Mike Pollard
Conservation Officer
Banbury Ornithological Society
Email:
conservation@banburyos.org

8 October 2019

RE Land Adjacent to Promised Land Farm, Application No: 19/01740/HYBRID and the linked application 19/01746/OUT

Project	Bicester Gateway
Drawing Title	Habitat Features Plan
Scale	As Shown (Approximate)
Drawing No.	11920/P01
Date	July 2019
Checked	AG

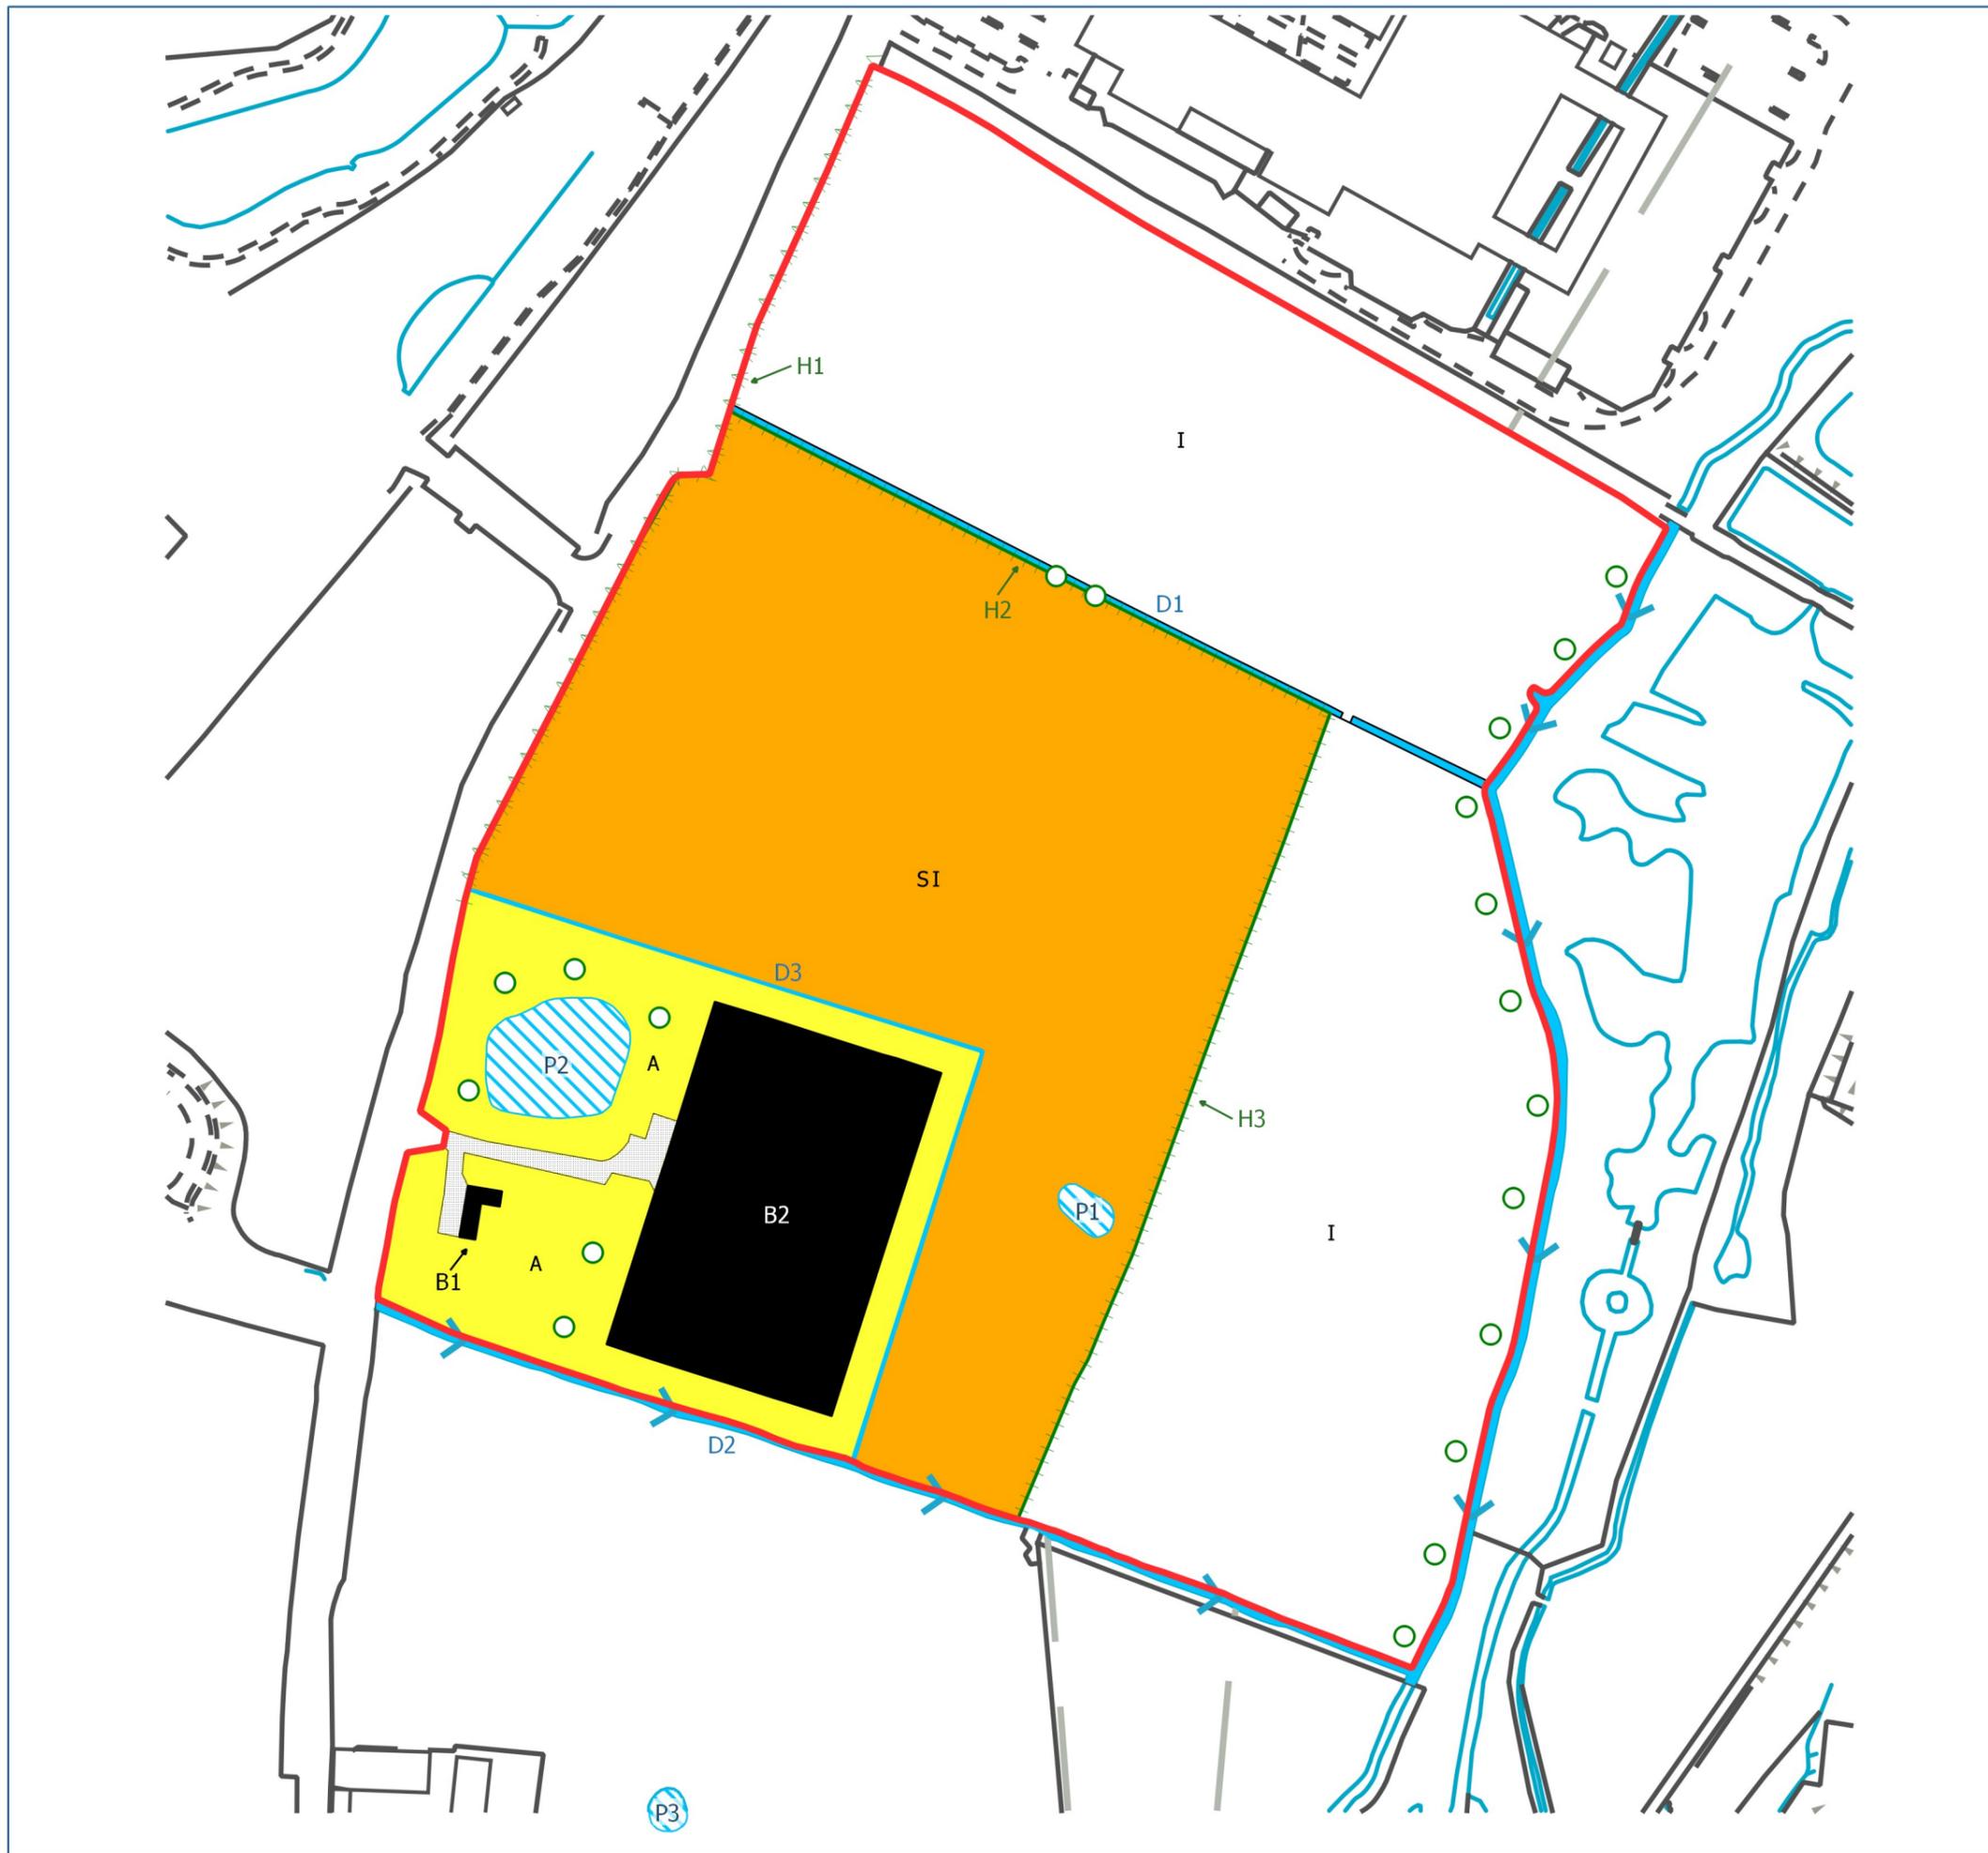
2. The grassland field adjacent to the access track to the nature reserve and sewage treatment works is one of the two fields classified as Improved grassland (Plot 3). We have observed that part of this field (the north-west portion) might justify classification as semi-improved as there are patches of Yellow Rattle and a more diverse floristic value than in the rest of the field. This part of the field is where the health and racquets club is proposed to be built. A brief walkover by a local botanist in June 2017 identified a number of indicators of semi-improved grassland were there, such as Meadow Buttercup, Yellow Rattle, Meadow Barley, Bird's-foot Trefoil, Meadow Vetchling and Oxeye Daisy. A single Bee Orchid was also identified. This field is also regularly used by feeding birds, especially Green Woodpeckers and Mistle Thrushes, joined in winter by flocks of Fieldfare and Redwing. Up to 6 Grey Herons and 35 Meadow Pipits have also been recorded feeding in this field. This indicates the presence of a significant invertebrate biomass, especially earthworms.

ZONE DEDICATED TO CONSERVATION 1:500

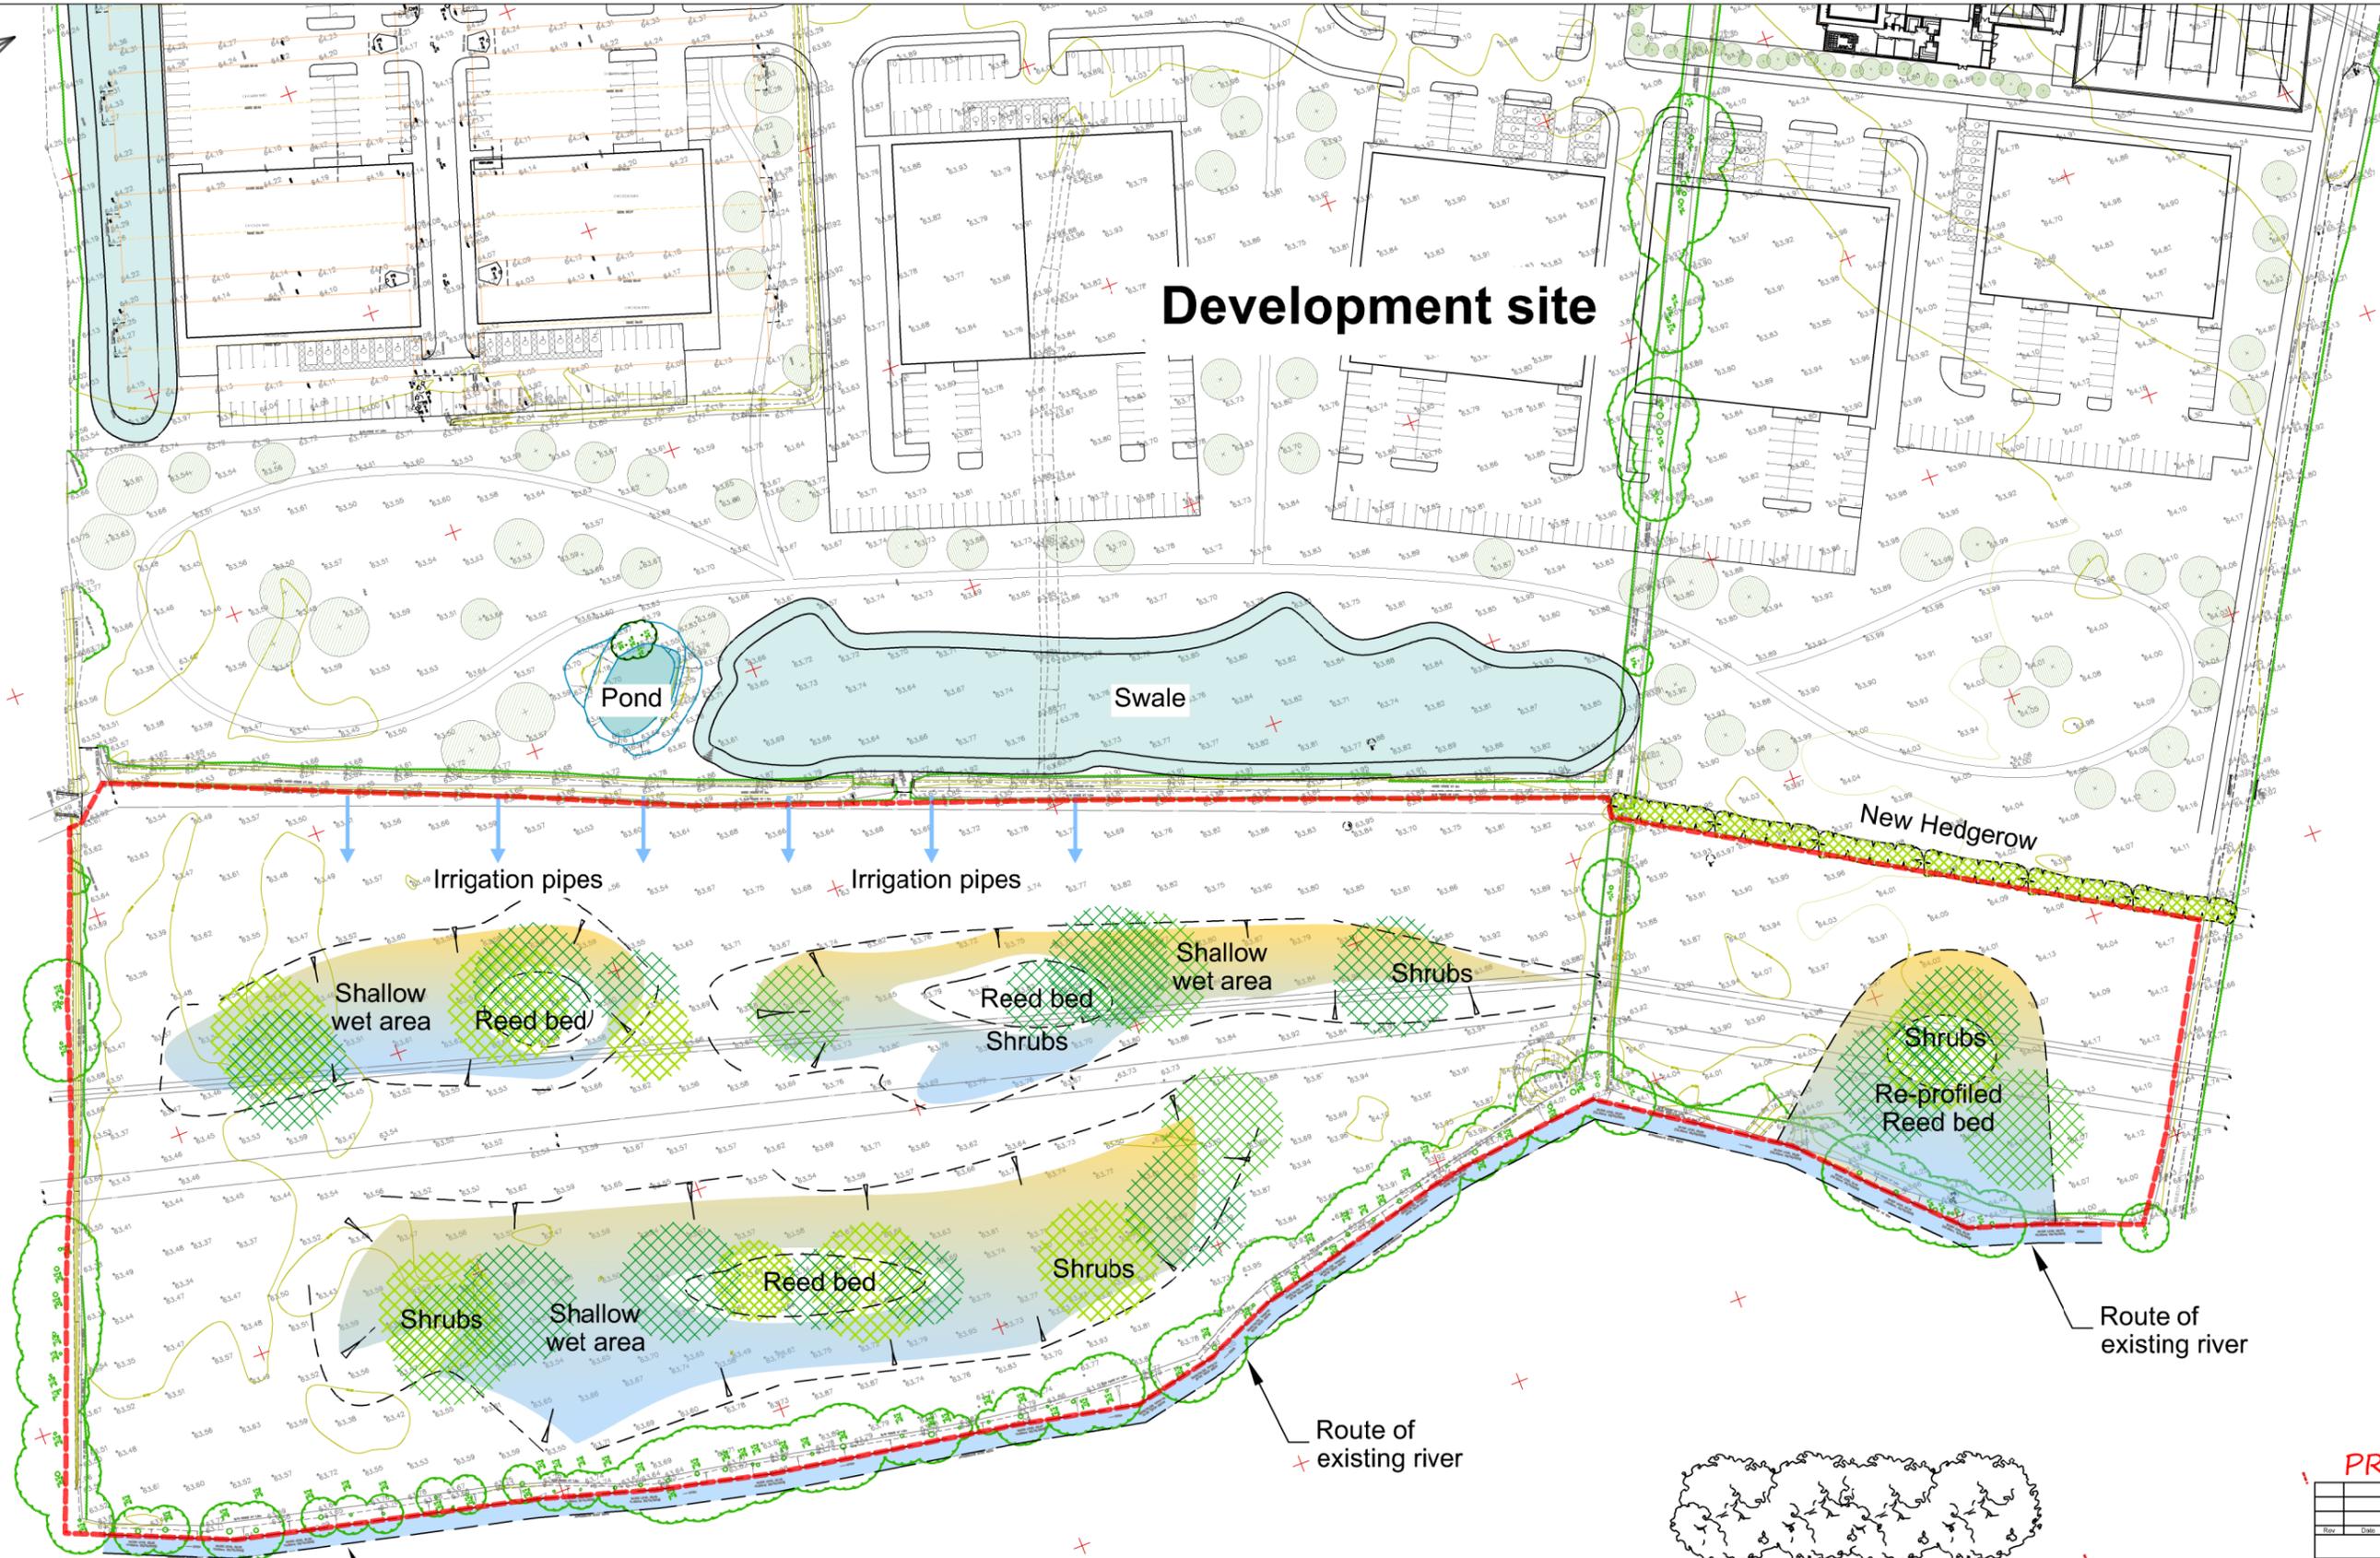
We have three specific comments on the Conservation Zone proposal:

1. It is important that the habitat is designed to be part of the established grazing system (that also includes most of the Bicester Wetland Reserve) managed from Promised Land Farm. This will enable the land to be managed simply and sustainably with local livestock to achieve the optimal wet grassland conditions for wetland wildlife, especially waterbirds.

2. Rather than planting scrub and reeds in the larger southern field, we would advise focussing on creating flower rich grassland around the shallow pools and confine any scrub planting to the field corners. This will make the wetland more suitable to wildfowl and waders that require good visibility. Reed planting would be better focussed on the smaller northern field, possibly in combination with excluding the livestock at times as cattle will rapidly graze the reeds.

3. The line of fine willow pollards that run alongside the Langford Brook have not generally been pollarded for many years. They are a very important ecological feature and provide habitat for numerous species as well as being of historical and landscape value. The long-term management of the willow pollards need to be included within the management plan for the Conservation Zone and funds provided for their management on a long-term basis.
